From: Miriam Hill
Sent: 26 April 2017 16:45
To: Mark Peacock
Cc: Planning
Subject: 6/2017/0550/MAJ: Land adjacent to Porsche Garage Hatfield Avenue

Proposal: Erection of a 75 bed elderly care home development (C2) with 20 parking bays and associated landscaping.

Drawing Title
Proposed Site Plan

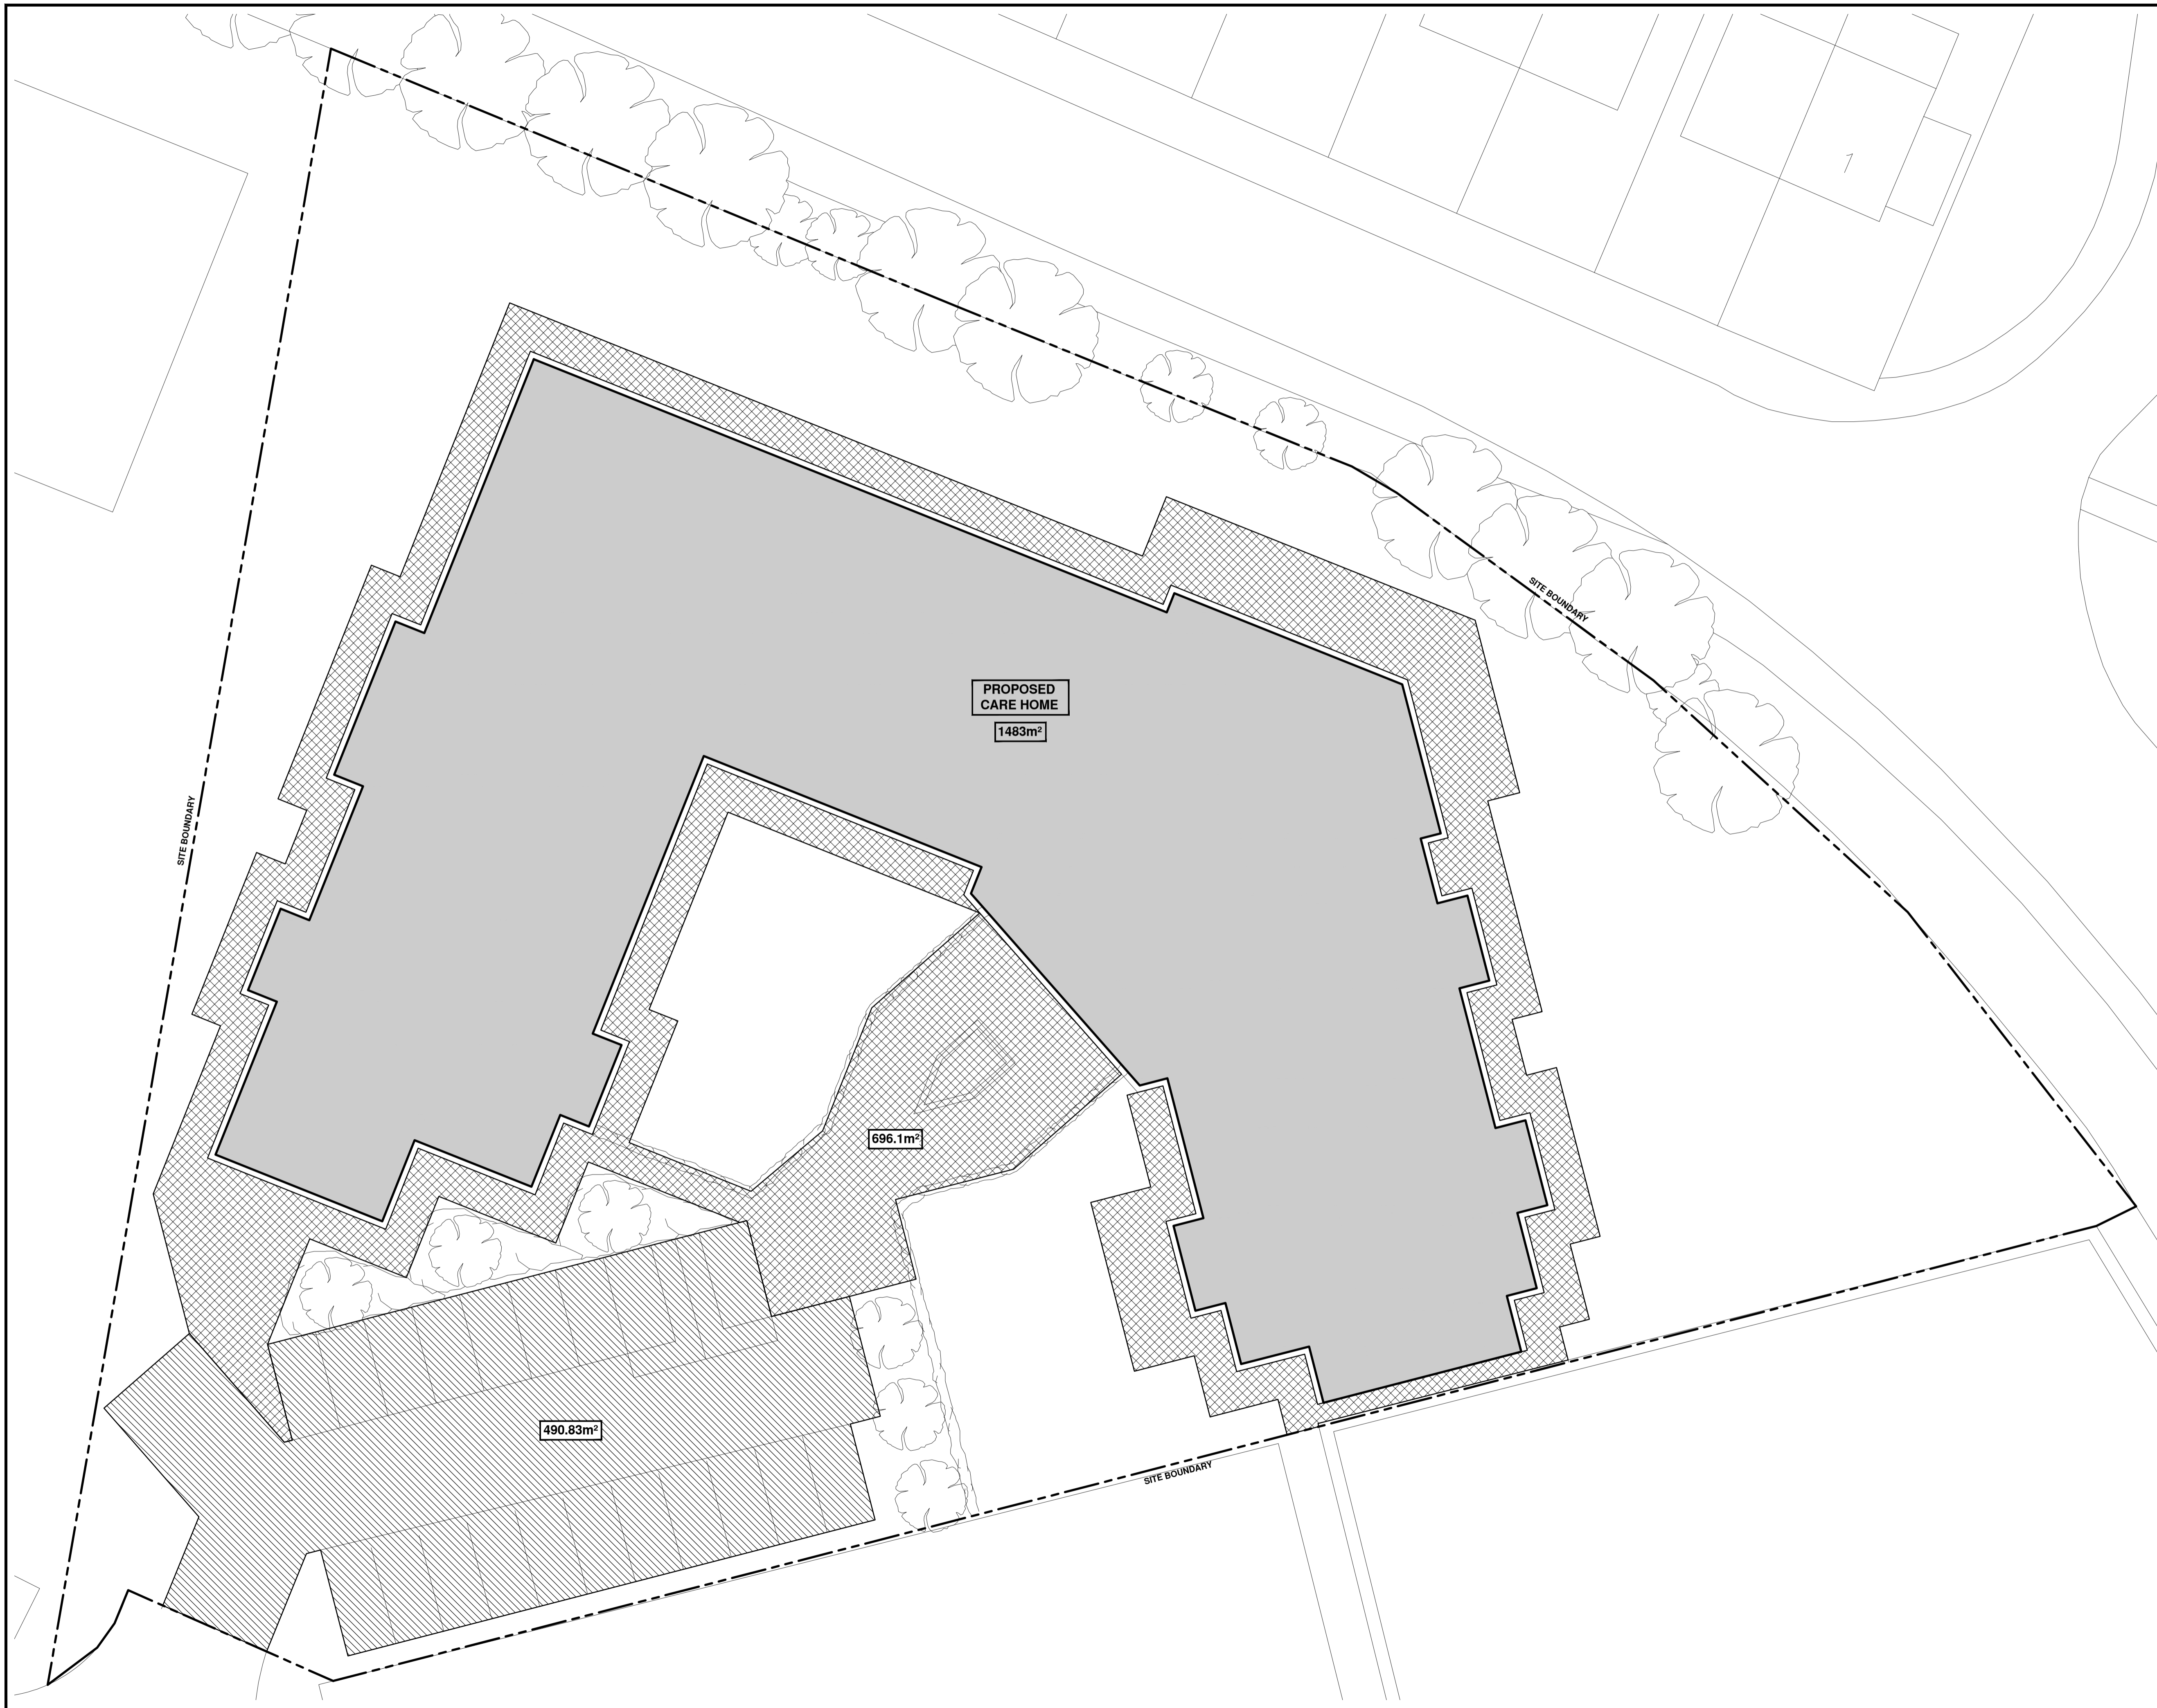
Western boundary (with plot 6000): There appeared to be some discrepancy between the 'Landscape Strategy' plan and the 'Proposed Site Plan'. One is more informal, the other formal. It would be better if the tree planting along this boundary was not one species planted uniformly as per the 'Proposed Site Plan'. A mixed tree planting is more appropriate but not so mixed that there is only one of several species. Larger or broader crowned trees should be inserted where there is more space. These do not need to be native species.
